Our Case Number: ACP-322958-25

Re: Athlone link road phase 2. Proposed link road, joining the Crescent Junction (R915) to Southern Station Road Junction
Athlone, County Westmeath

Subject: Objection to Proposed Road Construction [An Coimisiún Pleanála – Case Reference Number: JP25M.322958]

Drawing file: Drawings / 120278-5001 PL1 Vegetation to be Removed.pdf

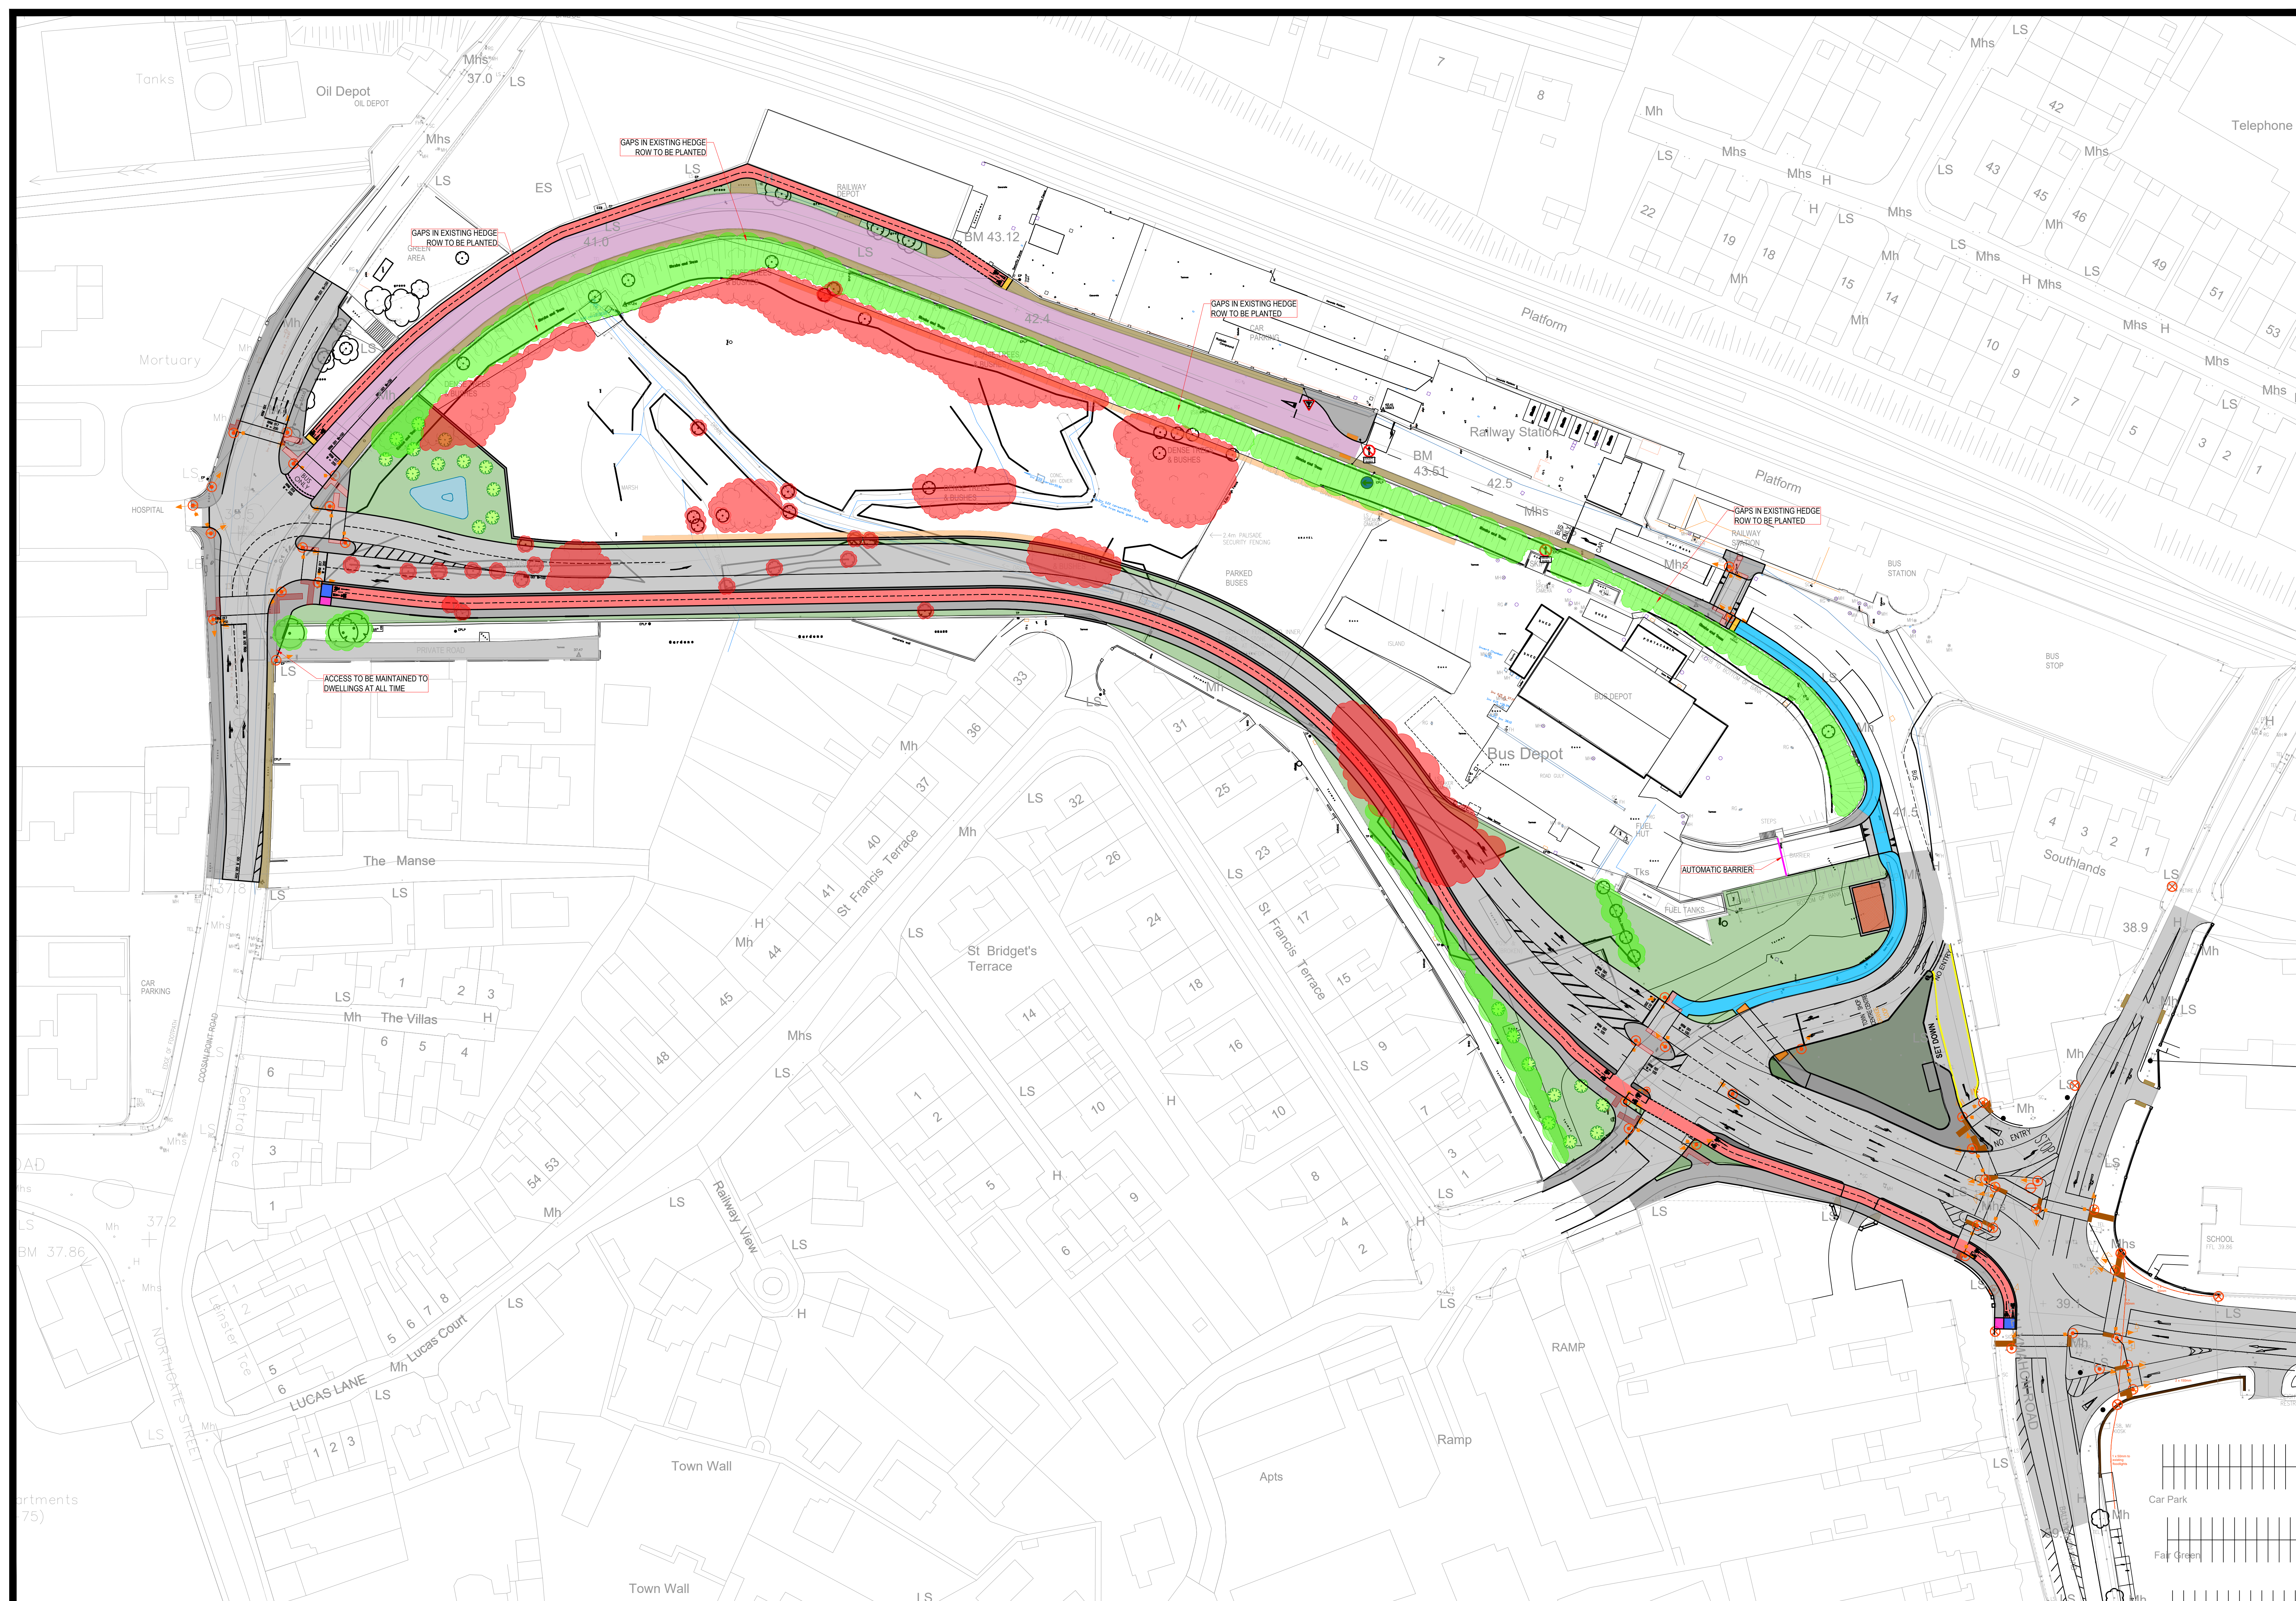
I must also draw attention to the document titles "*120278-5001 PL1 Vegetation to be Removed*". This document omits a significant number of trees and bushes that are clearly within the path of the proposed road and the planned bus depot expansion. Many of these trees are **native Irish hardwood species**, which are of particular ecological value and whose removal conflicts with Ireland's **National Biodiversity Action Plan 2023-2030** commitments. These omissions mean the document is inaccurate and fails to fully reflect the true environmental impact of the project.

Furthermore, I have been informed that the trees on my property, which borders the proposed roadway, will also need to be removed to facilitate the construction of the boundary wall. These trees, which also include native Irish hardwoods, are absent from the "*120278-5001 PL1 Vegetation to be Removed*" document, further highlighting its inaccuracy and the underestimation of environmental loss.
